KITTITAS COUNTY

TO: All Staff
FROM: Kelee Hodges, Engineer Tech 2 on behalf of Justin Turnbull, County Surveyor
DATE: March 15, 2022
SUBJECT: County Survey Review of BL-22-00002 Haberman

PART OF THE SOUTHWEST QUARTER OF SECTION 28,
TOWNSHIP 18 NORTH, RANGE 19 EAST, W.M.

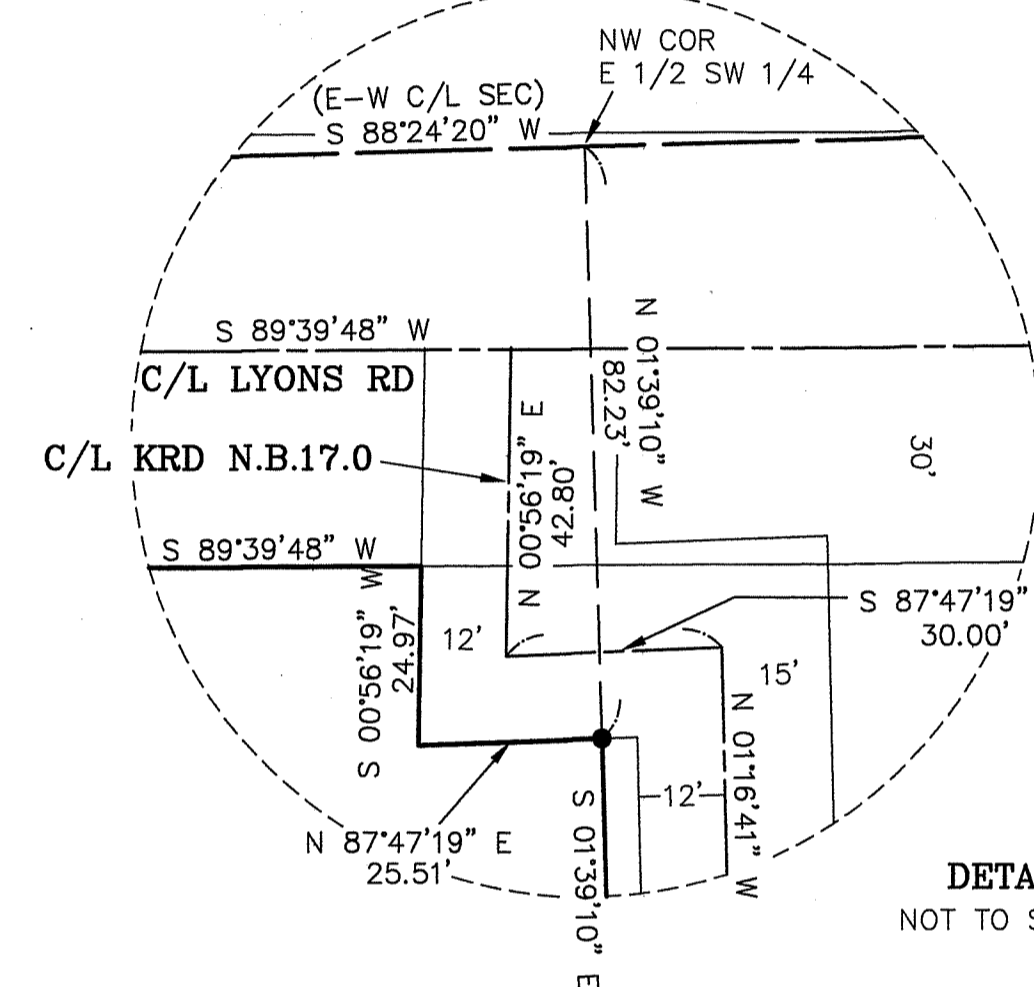
1. Distance label on northeast boundary of Tract 2 and west of the KRD may be difficult to read.

PART OF THE SOUTHWEST QUARTER OF SECTION 28, TOWNSHIP 18 NORTH, RANGE 19 EAST, W.M.

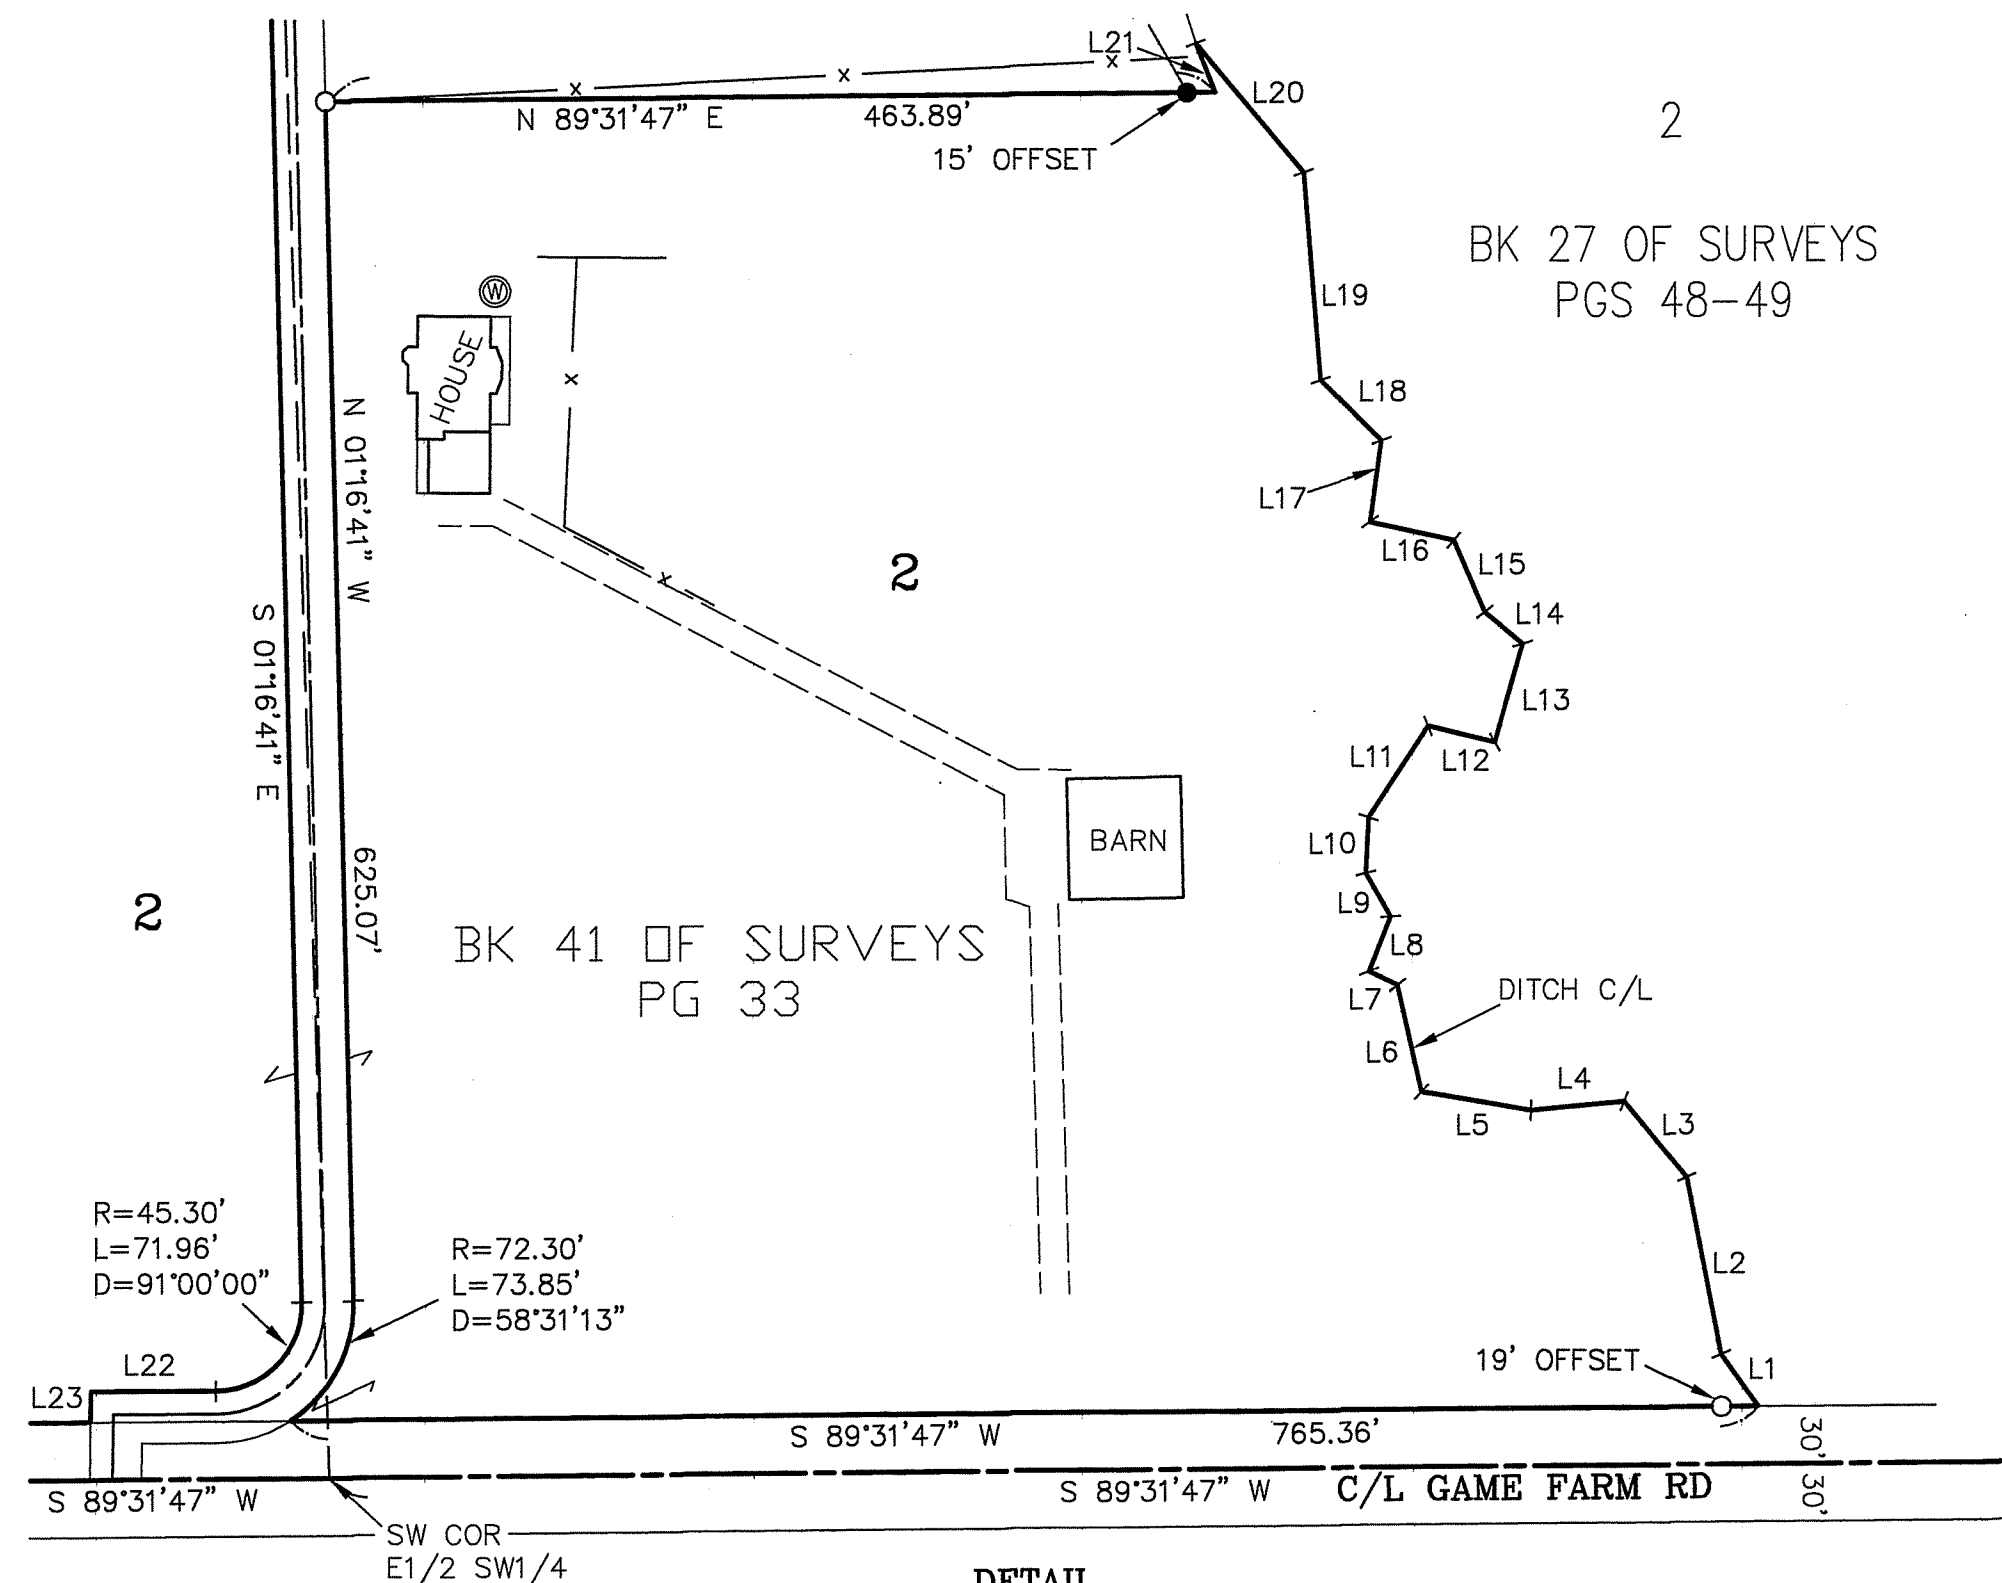
1. Line 17 in table on sheet 2 should read bearing N 07°58'52"E for 42.76'. Lot closure sheet does show correct bearing.
2. Encroaching fence on south boundary of Tract 1 and west boundary of Tract 2 should be identified in accordance with WAC:332-130-050(1)(f)(vii)
